8th February 2022
Ref: J2113_L2.doc

New Liverpool Primary School (18 Forbes Street, Liverpool)
Flood Emergency Response Plan – Response to Issues Raised

I refer to your email dated 8th February 2022, in which you requested clarification of a number of issues that were raised during the Department of Planning and Environment's review of the Flood Emergency Response Plan that was prepared by FloodMit Pty Ltd in November 2021. Our response to issues raised is provided below. The paragraph numbering is the same as that provided in the Department's email of 4th February 2022.

Illustration 1
Rate of Rise of Floodwater at Liverpool

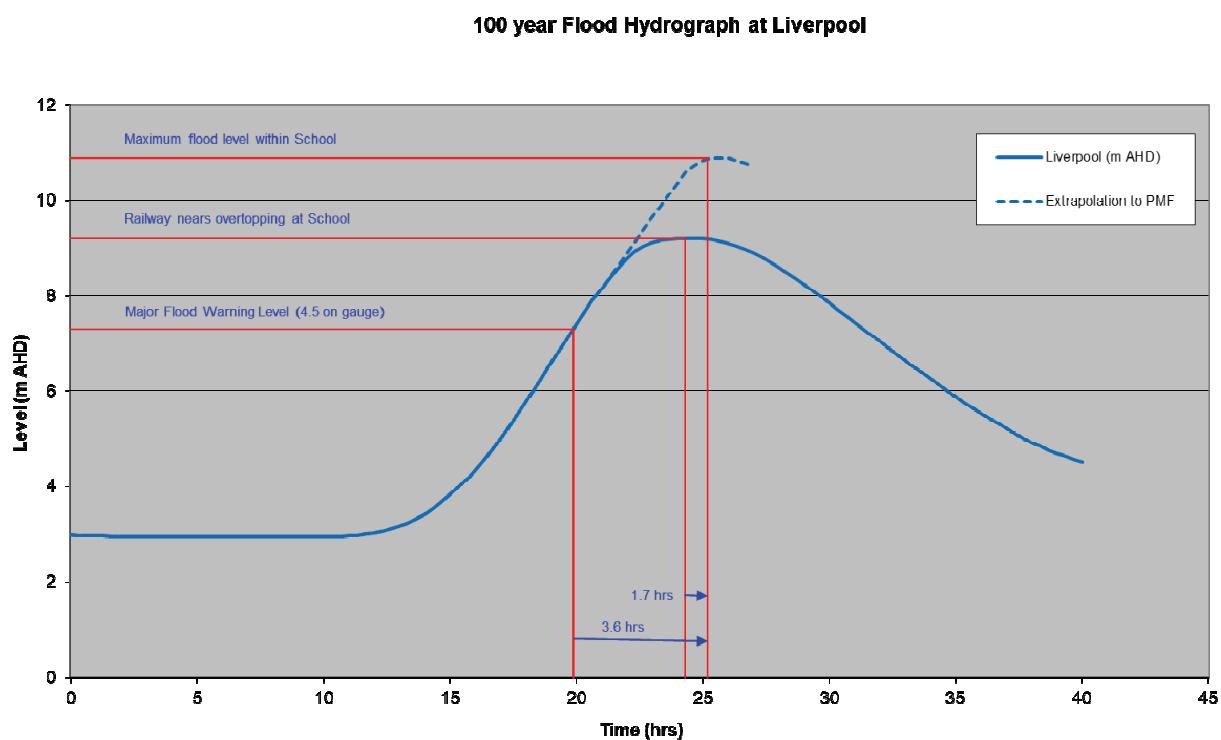
The Plan assesses warning times on the basis of the maximum rate of rise in a 100 year flood, assuming that this rate of rise continues up to the PMF flood level. This is shown in Illustration 1 from the FloodMit report. The review requested consideration of warning times based on the actual PMF flood hydrograph.

Design flood levels provided in the Plan are those that have been formally adopted by Liverpool Council. The source of this data is the Georges River Flood Study (PWD, 1991). This is based on a physical scale model that was developed by the University of NSW. Unfortunately, PMF hydrographs were not included in that report, and the physical model is no longer available. Consequently, we have relied on results from a numerical MIKE-11 model that was developed as part of the Georges River Floodplain Management Study (Bewsher, 2004). This model was calibrated by Bewsher to match results from the physical model for the 100 year flood, and was found to provide "reasonable agreement" for other flood events. The PMF flood hydrograph has been extracted from this model and included in Illustration 1 for reference purposes (attached).

The PMF flood rises much quicker than the 100 year flood in the early stages of that event, but then appreciably slows and very gradually rises as the peak of the PMF flood is approached. This is because the PMF event is dominated by downstream flood conditions that are experienced at East Hills, some 17km downstream. The PMF is nearly 5.0m higher than the 100 year flood at East Hills due to the restricted downstream floodplain. As flood levels at East Hills continue to rise in a PMF event, backwater influences gradually extend upstream towards Liverpool, and the PMF event at Liverpool takes longer to peak than the 100 year flood.

The peak of the PMF flood at Liverpool occurs slightly later than the peak of the 100 year flood. By the time that a “major flood warning” level at Liverpool is reached, there is 3.6 hours until the maximum flood level is reached within the school based on the rate of rise of the 100 year flood, but approximately 12 hours based on the PMF hydrograph.

The assumed maximum rate of rise in a 100 year flood (as adopted in the flood emergency response plan) provides a conservatively low estimate of the time available in which to appropriately respond to the flood emergency.
